Planning Services Sign Permit Review Form

| Date of Submittal | Application Number | Applicant | Landowner |
|-------------------|--------------------|------------------------|-----------------------------------|
| 6/20/2023 | SIGN2306-0002 | Mccorkle Sign Co. Inc. | Harnett County Board of Education |

| Contact Person | Contact Number | Sign Location | PIN Number |
|----------------|----------------|---|------------------|
| Krista Cole | (919) 687-7080 | 736 Rollins Rd. Fuquay-Varina Must be revised to be an internal sign at the school | 0645-78-2045.000 |

OVERALL SITE LAYOUT

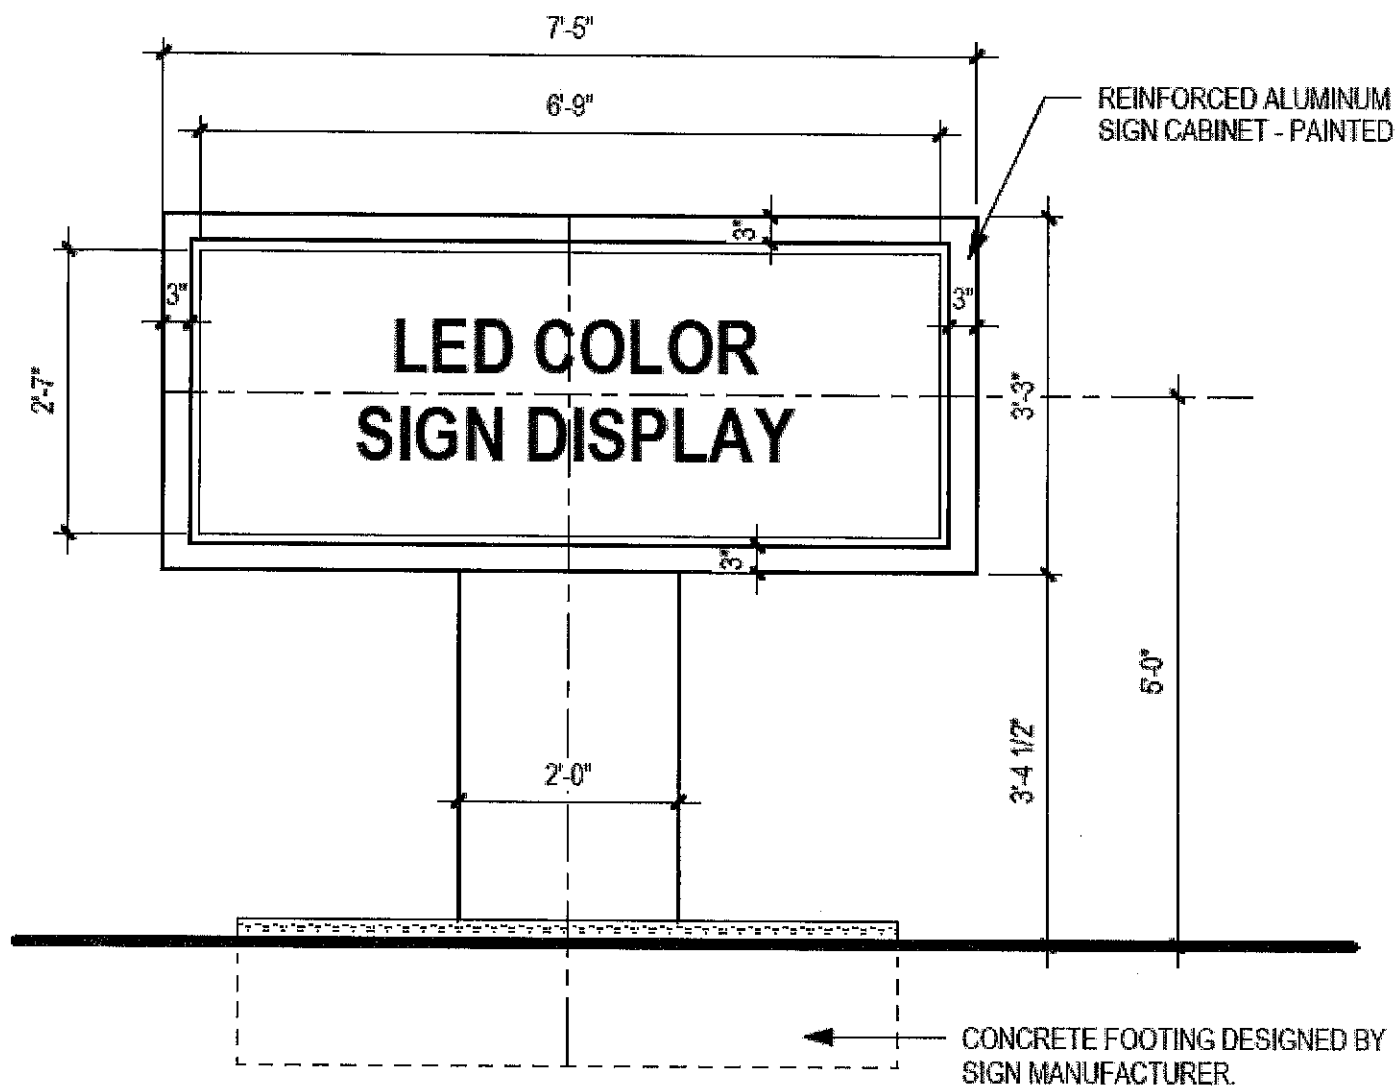
| Proposed Sign | | | |
|--|--|--|---|
| <input type="checkbox"/> Wall <input checked="" type="checkbox"/> Ground <input type="checkbox"/> Monument <input type="checkbox"/> Directory <input type="checkbox"/> Outdoor Advertising | Height 79.5" Width 89" Total Sq. Ft. | Setbacks for the sign are not provided on the current site plan. The site plan requires revision as the proposed location of the current sign must be revised. | <input type="checkbox"/> None <input type="checkbox"/> External <input type="checkbox"/> Internal <input checked="" type="checkbox"/> Electronic Message |

| Comments | <p>Please submit a revised site plan that includes the distance from the internal LED message display sign and the existing monument sign. A distance of 300' from the existing monument sign is required. Please update the site plan to show the newly proposed location of the LED message sign. The sign should be oriented away from the ROW in a manner that it is reasonable to state that the sign is only used to display information on site. Remove the highlight around the monument sign that will be permitted separately. If the existing sign does not require building plan review due to size, it will still require zoning review. Please contact Central Permitting to begin the sign permit for the existing monument sign.</p> |
